WEST SUSSEX COUNTY COUNCIL CONSULTATION

TO:	Arun District Council FAO: Ms M Tomalova
FROM:	WSCC - Highways Authority
DATE:	10 June 2019
LOCATION:	Garage Premises Main Road Yapton BN18 0EA
SUBJECT:	Y/22/19/PL Demolition of existing redundant garage building & erection of 1 No. dwelling and associated works (alternative following Y/68/17/PL). This application may affect the setting of listed buildings & may affect the character & appearance of the Main Road/Church Road, Yapton Conservation Area.
RECOMMENDATION:	No Objection

PROJECT	CLIENT	DATE	DRAWN
Reptune Garage site Main Road YAPTON	P Mountford	Feb 2019	pm
DRAWING	SCALE	DRAWING NO	REV
Block plans as existing and proposed	1:500@A3	1801/07

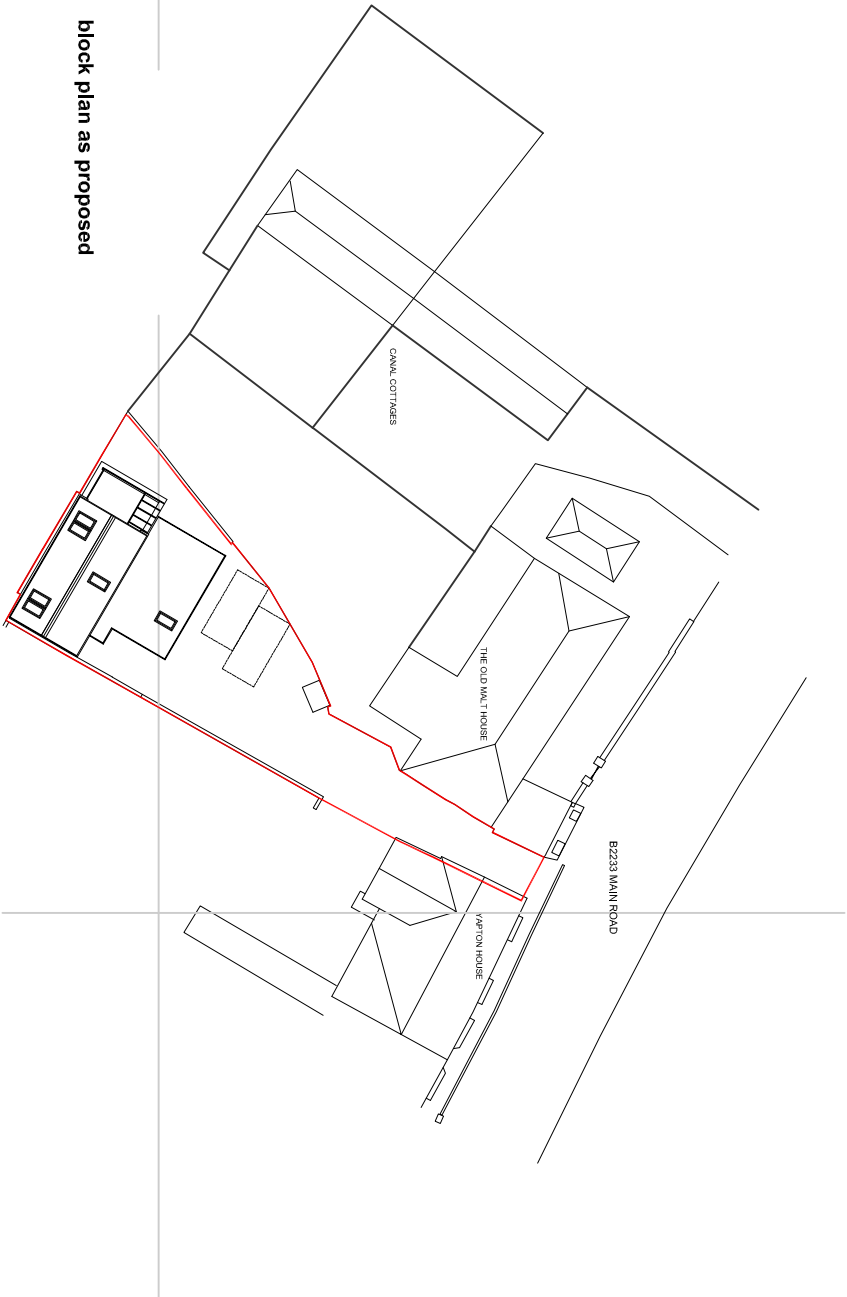
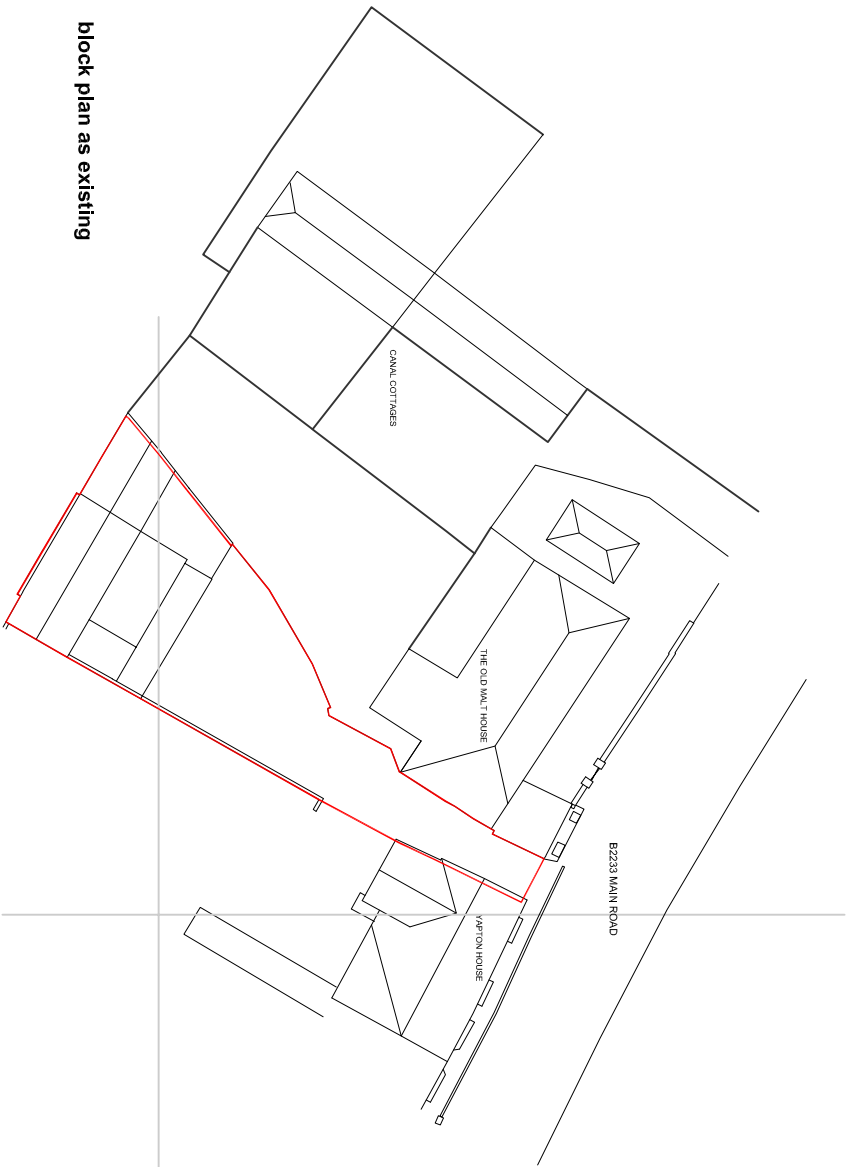
West Sussex County Council, in its capacity as the Local Highway Authority (LHA), have been re-consulted on proposals for demolition of garage building and erection of 1 x dwelling. In comments dated 5th April 2019 further information was requested regards the revised car parking arrangement and concern that space would not be available on site for turning.

The applicant has provided swept path tracking diagrams which demonstrate a large car can access the proposed spaces and perform a turn on site in order to exit in a forward gear.

Vehicle parking and turning

No part of the development shall be first occupied until the vehicle parking and turning spaces have been constructed in accordance with the approved plan. These spaces shall thereafter be retained for their designated use.
